Address: 40 Ganton Way Huddersfield HD22ND

Application number: 2023/91287	
What is the application for?:	Erection of detached building to create dwelling forming annex accommodation ass
Address of the site or building:	10, Fulneck Close, Fixby, Huddersfield, HD2 2LJ
Postcode:	HD2 2LJ

Proposed East

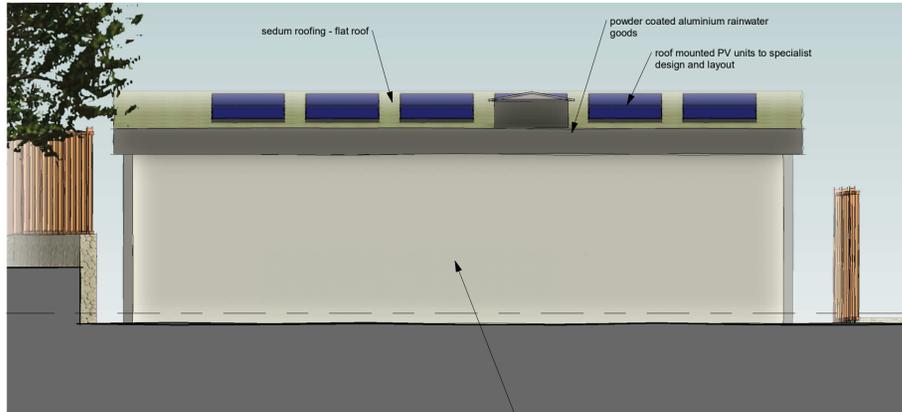
Type of comment: An objection	
Do you wish your comments to be published on the website anonymously?	No
<p>The proposed development will back directly on to our property, should the height of the development be higher than the existing boundary fence it will have a significant adverse affect on our outlook.</p> <p>I would also comment that the application clearly shows and states "existing patio feature across the whole of the planned area, it is our belief that the patio does not exist across the whole planned area.</p>
